ATLASSIAN OFFICE AND HOTEL DEVELOPMENT SSD-10405 MOD 1 - RESPONSE TO REQUEST FOR ADDITIONAL INFIRMATION

The RFI is in relation to a Section 4.55(1A) modification application (MOD 1) for the approved State significant development SSD-10405 which approved an office and hotel accommodation development at 8-10 Lee Street, Haymarket.

DPE have identified a number of additional minor changes shown on the architectural plans submitted alongside MOD 1 which were not approved in the plans as part of SSD-10405. DPE has requested clarification and justification for any additional design changes sought.

DA-09B-B01-00

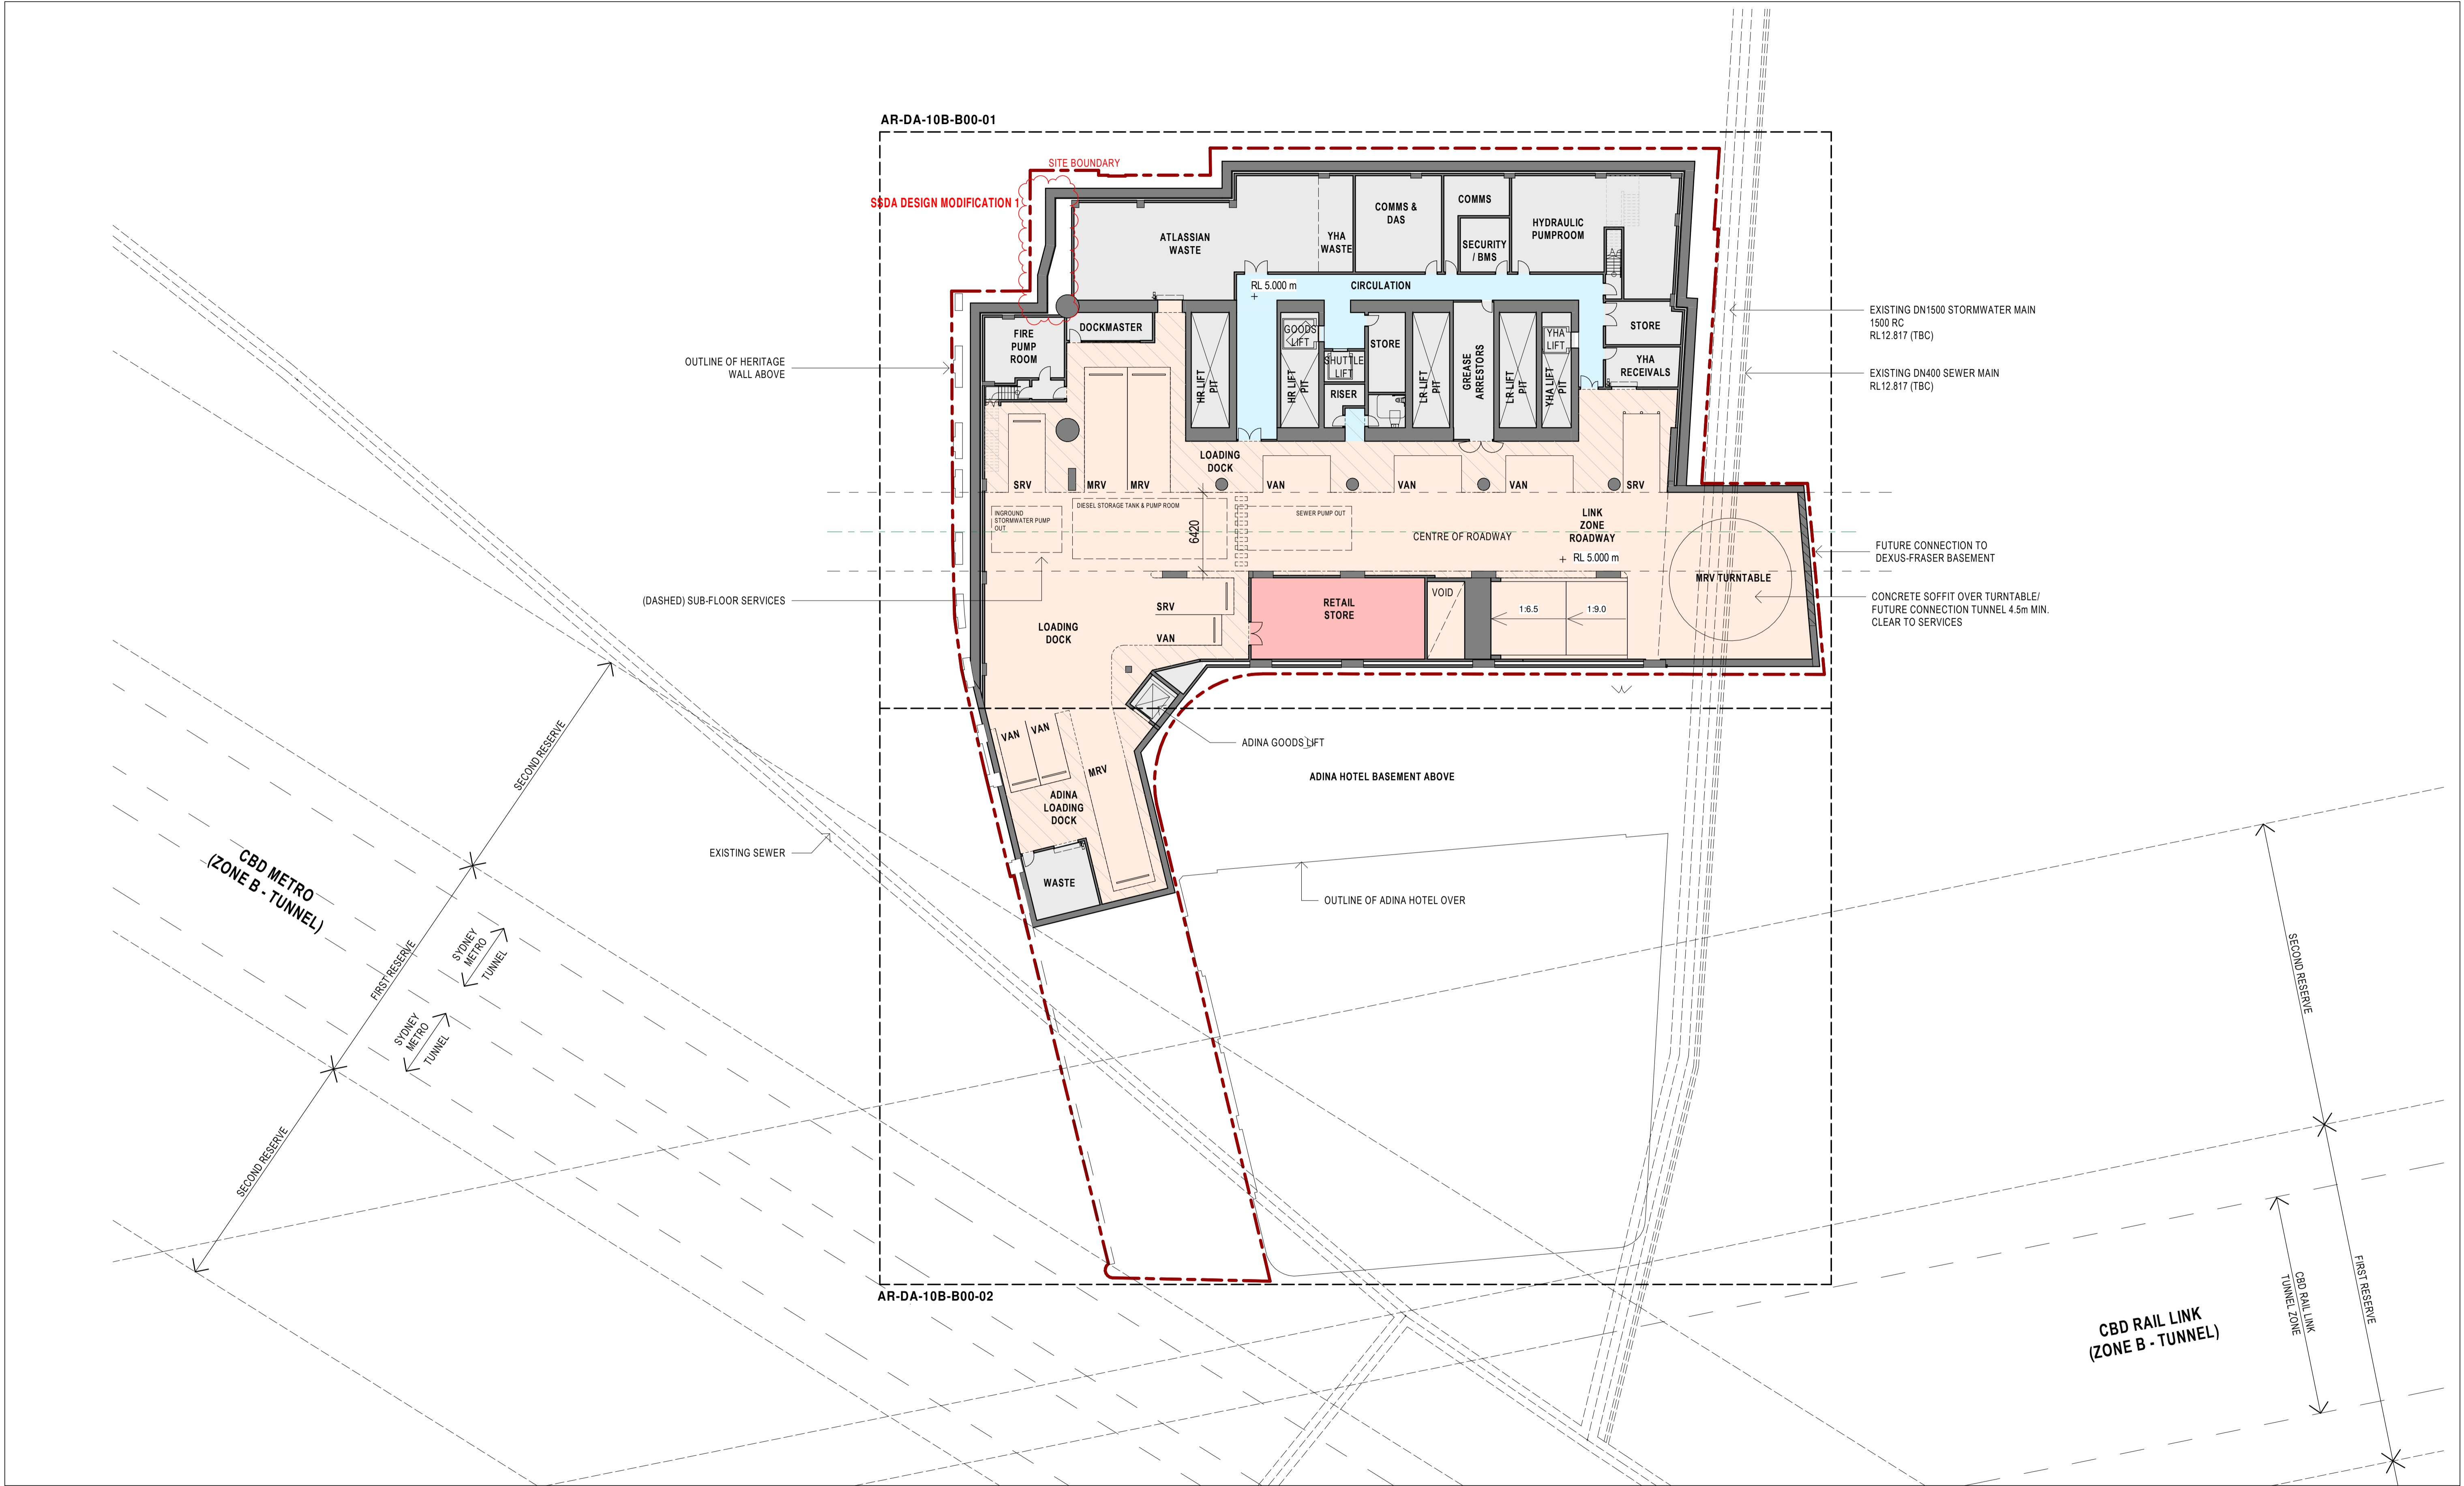
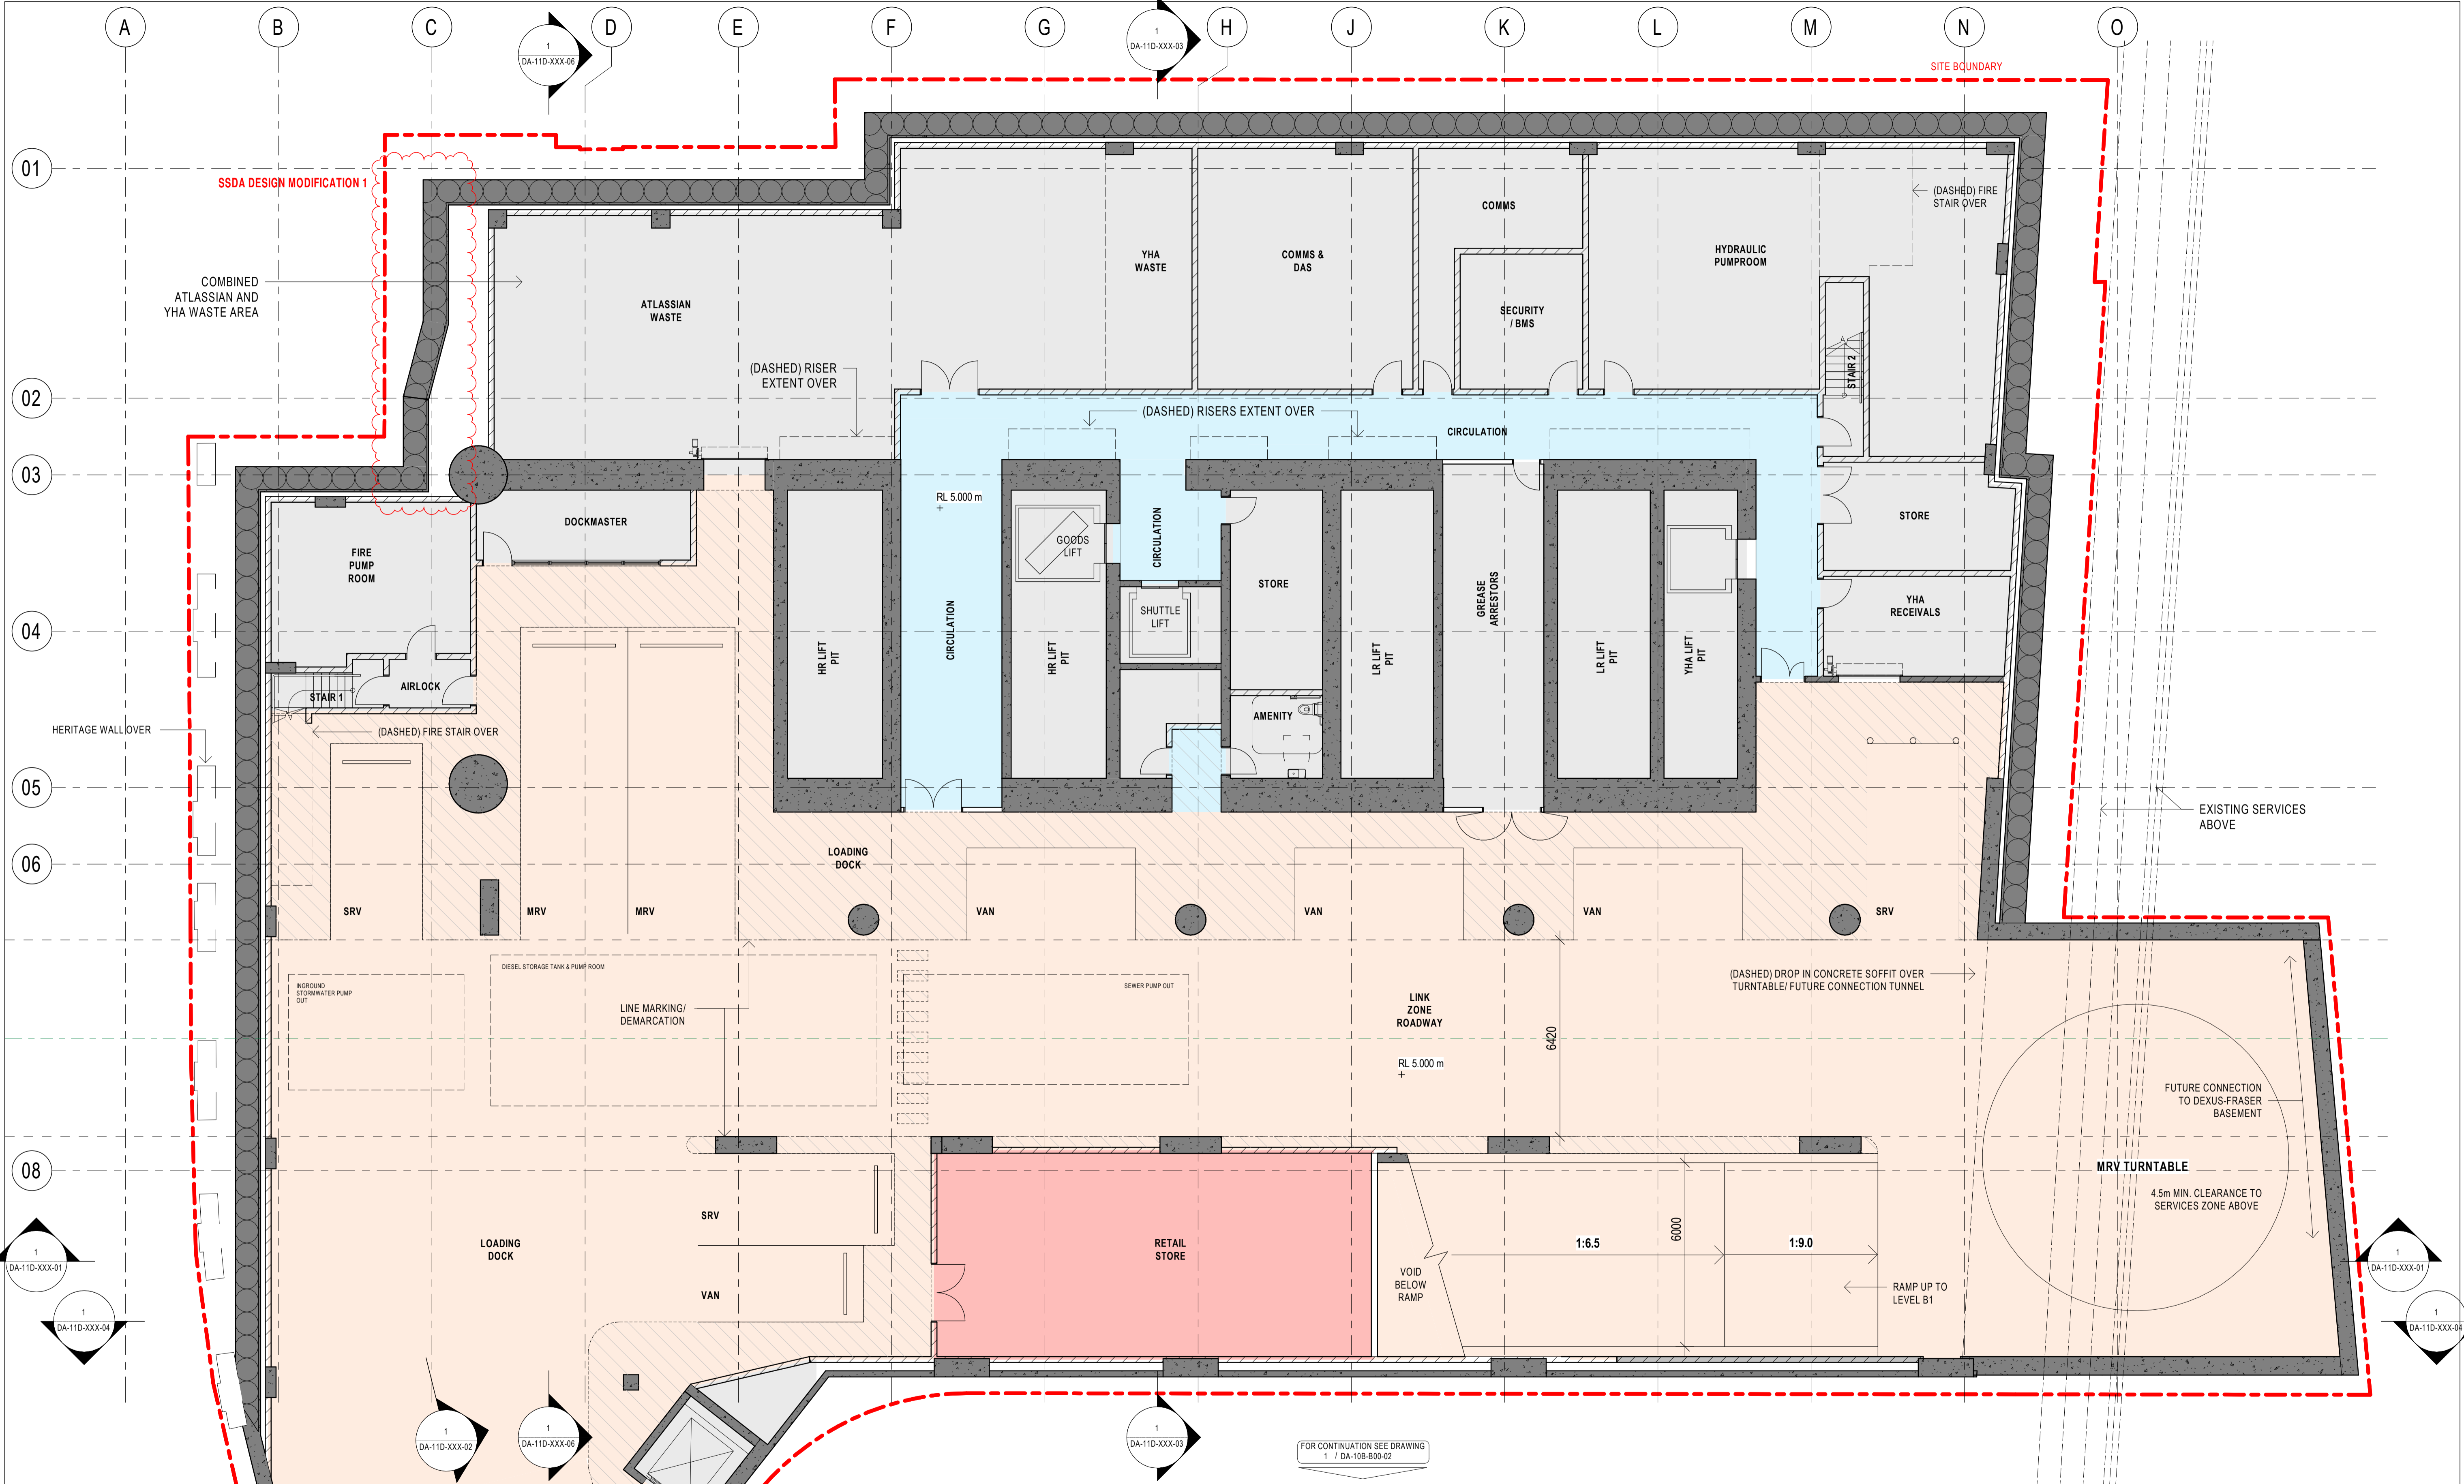
1. DA-09B-B01-00 rev 8 / Updated survey information regarding subterranean elements comprising the neighbouring building (Adina Hotel)
2. DA-09B-B01-00 rev 8 / Minor development on internal planning to toilet areas inside the End of Trip Facility, which are superseded by changes addressed in the MOD 2 Submission recently lodged.
3. DA-10B-B01-01 rev 8 / identical to the above.
4. DA-10B-B01-01 rev 8 / Graphical error on the drawing showing an incorrect overlay of Structure, which is superseded by changes addressed in the MOD 2 Submission recently lodged.

Update plans have been prepared by SHoP and BVN resolving issues 2-4 above. It is noted that the updated survey information has been left on the plans as this is part of a neighbouring building and does not constitute any change sought under MOD 1.
